**WATER SUPPLY INFORMATION SUMMARY**  
STATE OF COLORADO, OFFICE OF THE STATE ENGINEER  
1313 Sherman St., Room 821, Denver, CO 80203  
Main (303) 866-3581 water.state.co.us

1. NAME OF DEVELOPMENT AS PROPOSED: GRANDWOOD RANCH

2. LAND USE ACTION: SUBDIVISION / FINAL PLAT Plat drawings indicate project is 150.96 acres in size

GRANDWOOD.DWG
MAY 26, 2021
PROJECT 18062
SHEET 1 OF 3

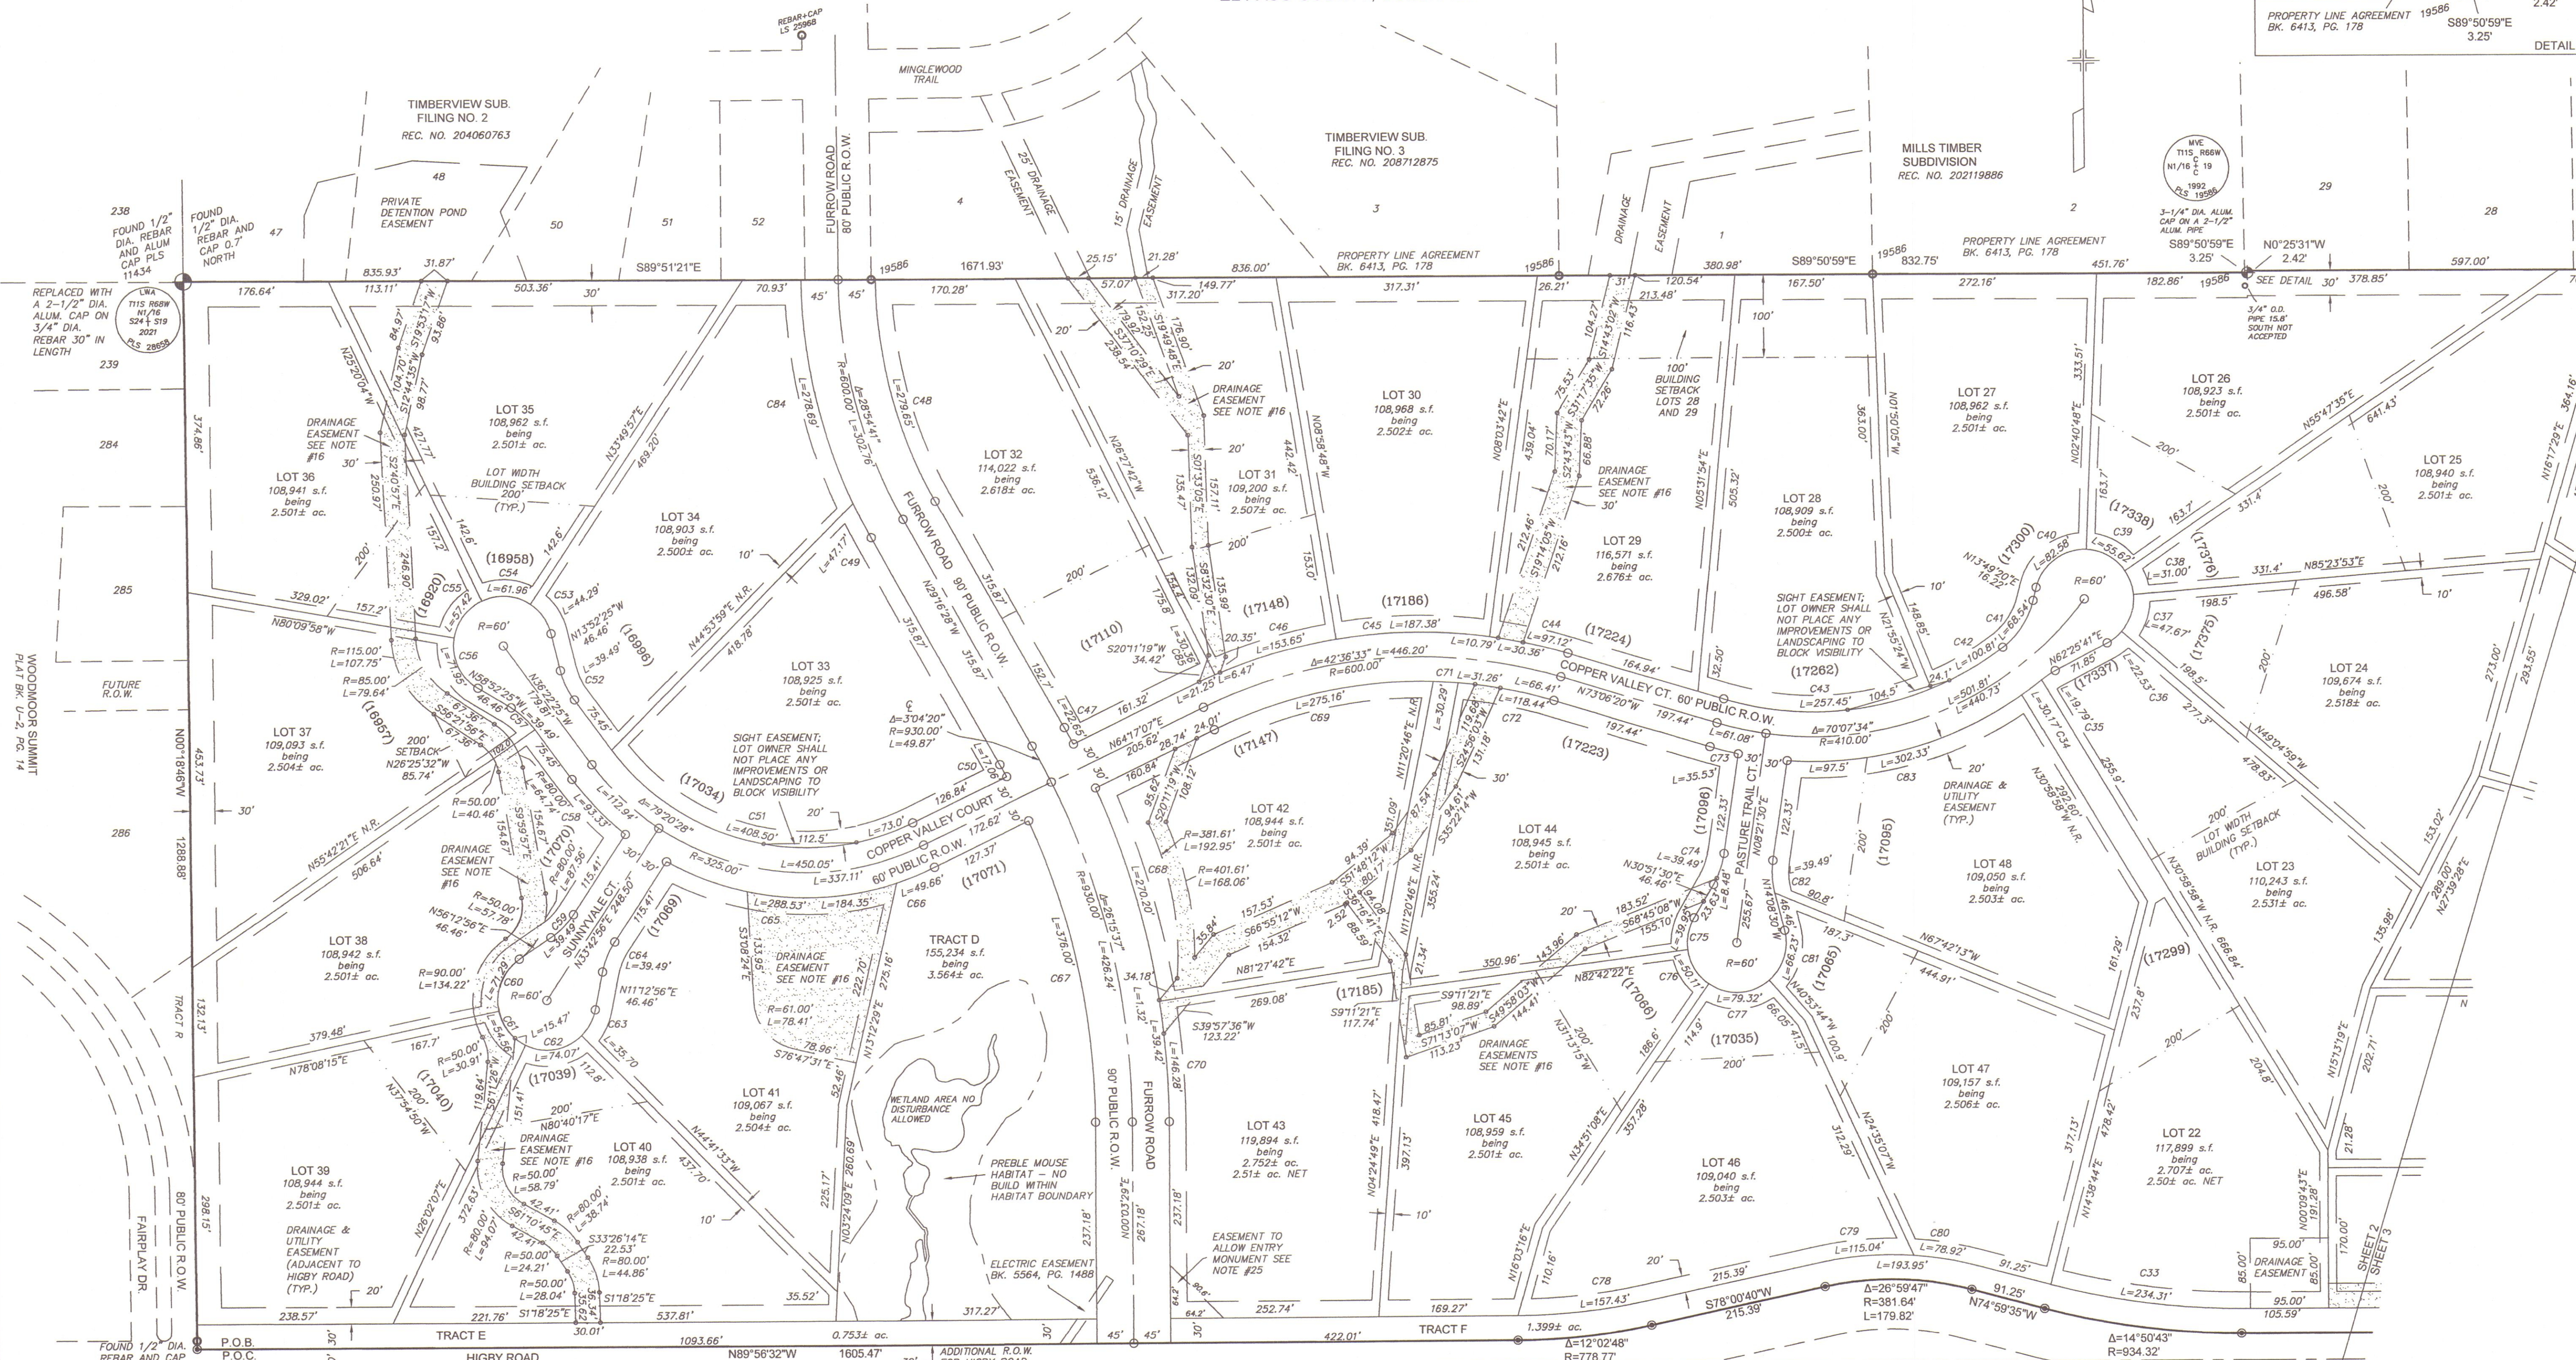
Plat drawings indicate project is 150.96 acres in size
